Norfolk County Council Comments on Sheringham and Dudgeon Extension Projects

Section 56 Submission Development Consent Order (DCO) Application

Figure 8-4: 1 in 100 year plus 40% for climate change Baseline (existing) flood depth

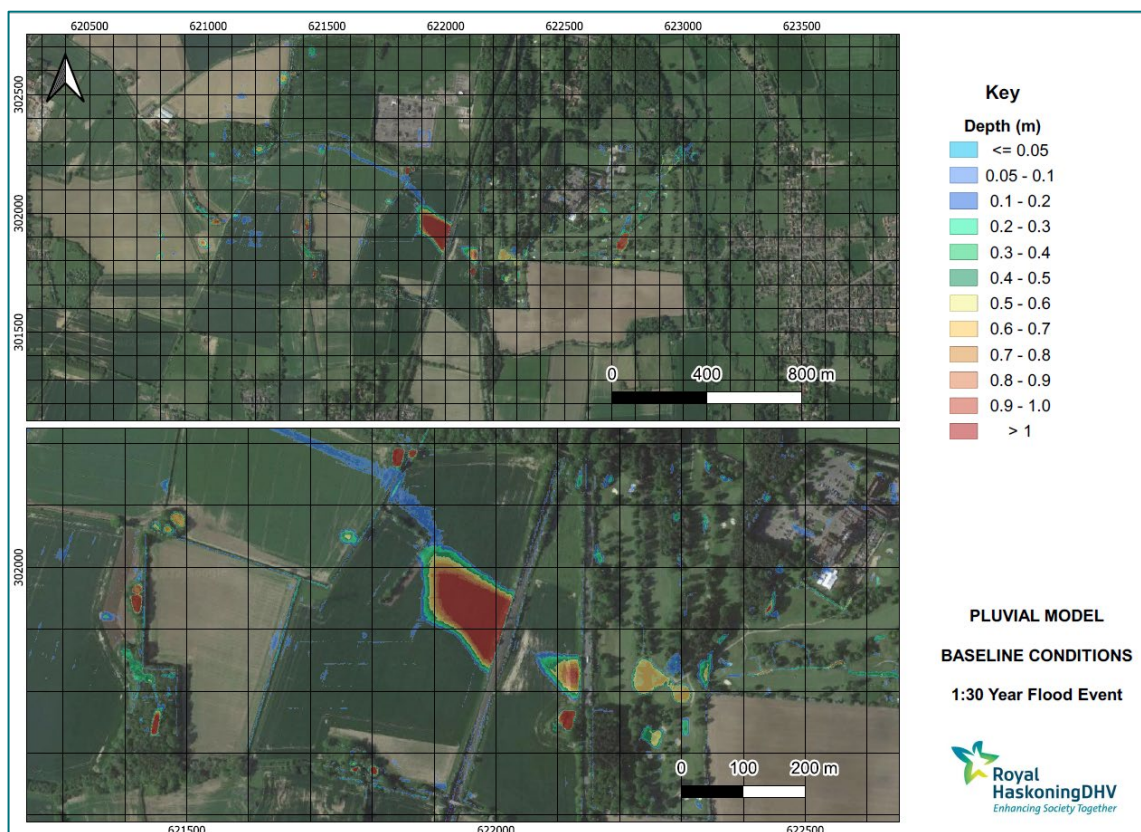
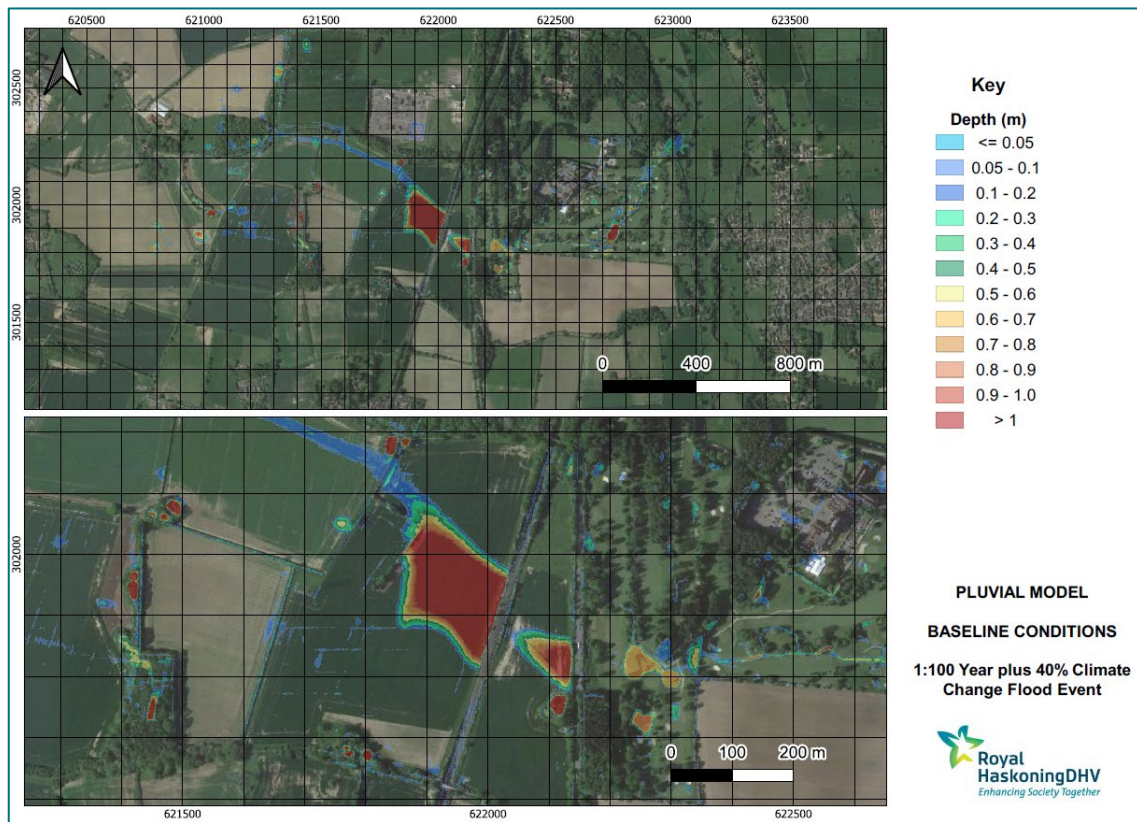
- 6.9. In Plates 2 to 5 (pages 69-72), the LLFA notes the surface water hydraulic modelling results are not consistent with the latest national guidance for climate change allowances. The LLFA requires for this modelling to be updated to incorporate the latest climate change allowances.

- 6.12. In the hydraulic modelling report, the hydraulic modelling must be updated for the 1% and 3.3% future scenarios in accordance with the latest climate change allowance guidance.

Figure 9-25: 1 in 100 year (plus 45% for climate change) comparison of changes in flood depth

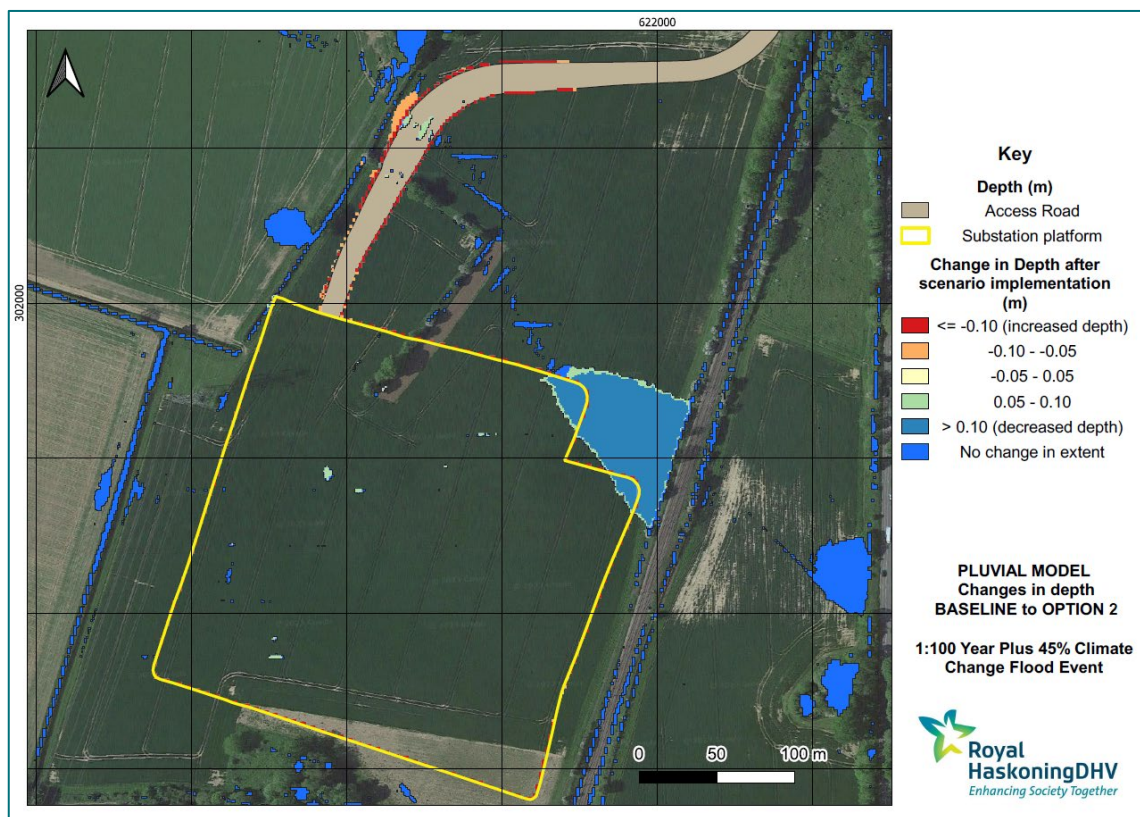
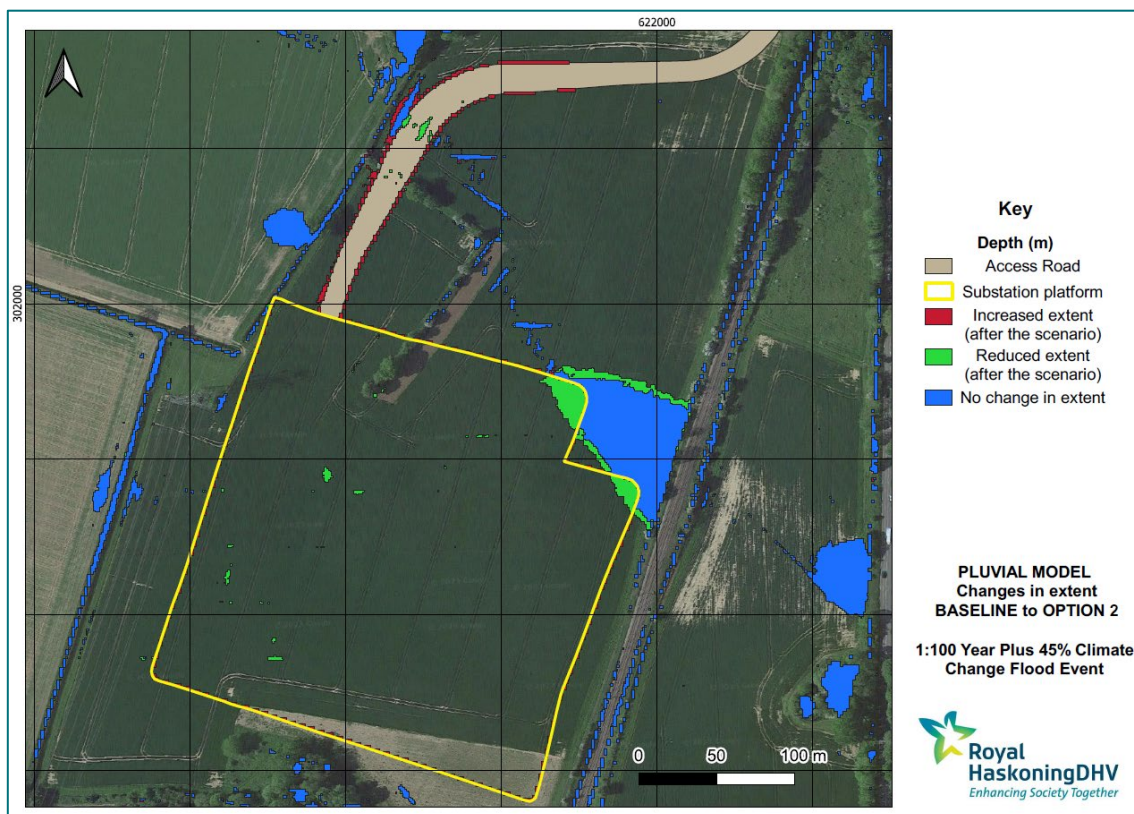
- 6.15. The LLFA requires that the applicant provides confirmation of the change in flood risk through a series of figures depicting the areas where a change in maximum flood depth and extent are experienced between the baseline and the post development scenario.
